November 14, 2024

25A/F-W/MP 157.40  
El Paso County

RE: Urban Landing PUDSP Combined PUD/Preliminary Plan

URBAN LANDING
PRELIMINARY PLAN
PRELIMINARY DRAINAGE REPORT
PRE-DEVELOPMENT MAP

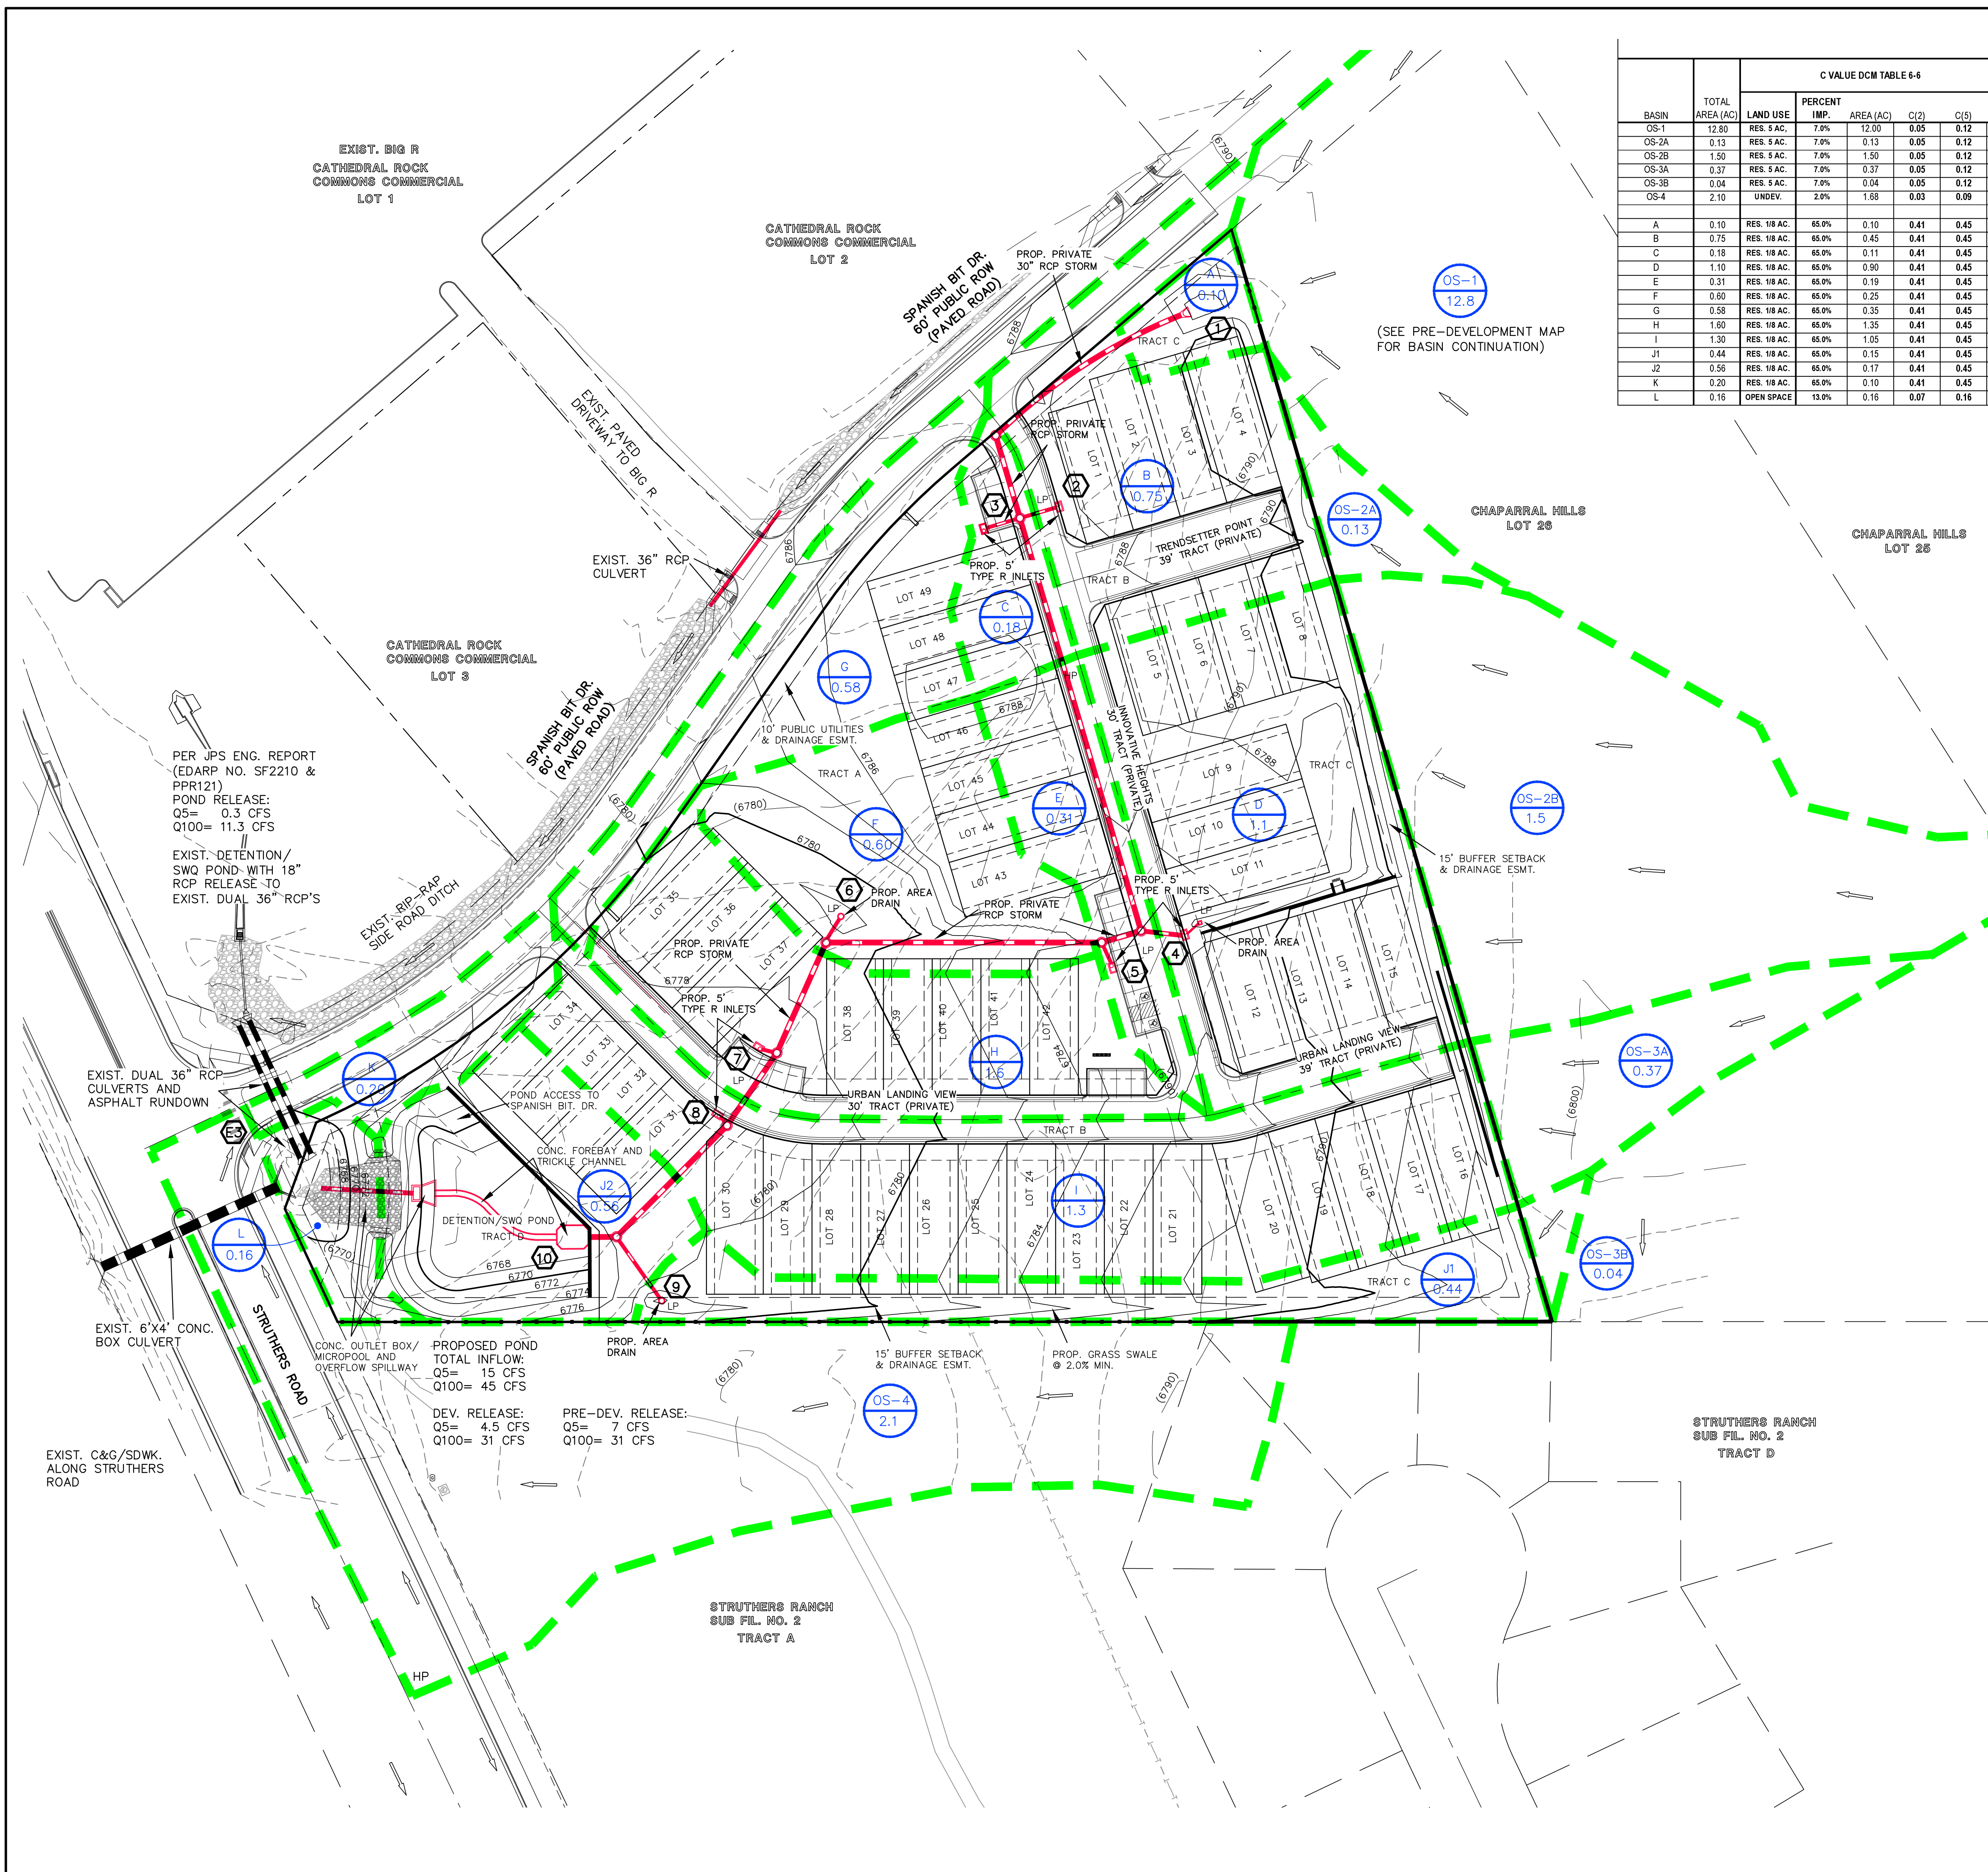
The Preliminary Drainage Report for Urban Landing dated 10/24/2024 has been reviewed by a CDOT Hydraulic Engineer; all comments for preliminary design have been resolved. Their comments are as follows:

- Plan Comment:
  - For the final design submittal, include detailed design plans of the pond.
- Report Comments:
  - For the final design submittal, include design point comparison for the flow into the existing culvert beneath Struthers.
  - For the final design submittal, include analyses of the Struthers culvert for existing/proposed/pond overtopping events. Based on the pond analyses included, there appears to be an increase of runoff into CDOT ROW when the spillway is utilized. Analysis needs to be included to verify that I-25 will not be impacted and what erosion protection is warranted. If there are increases to CDOT ROW, analysis of the I-25 culvert would be needed as well.
- This is the Preliminary Report, these comments can be addressed with the Final Design as compared to a revised Preliminary report.
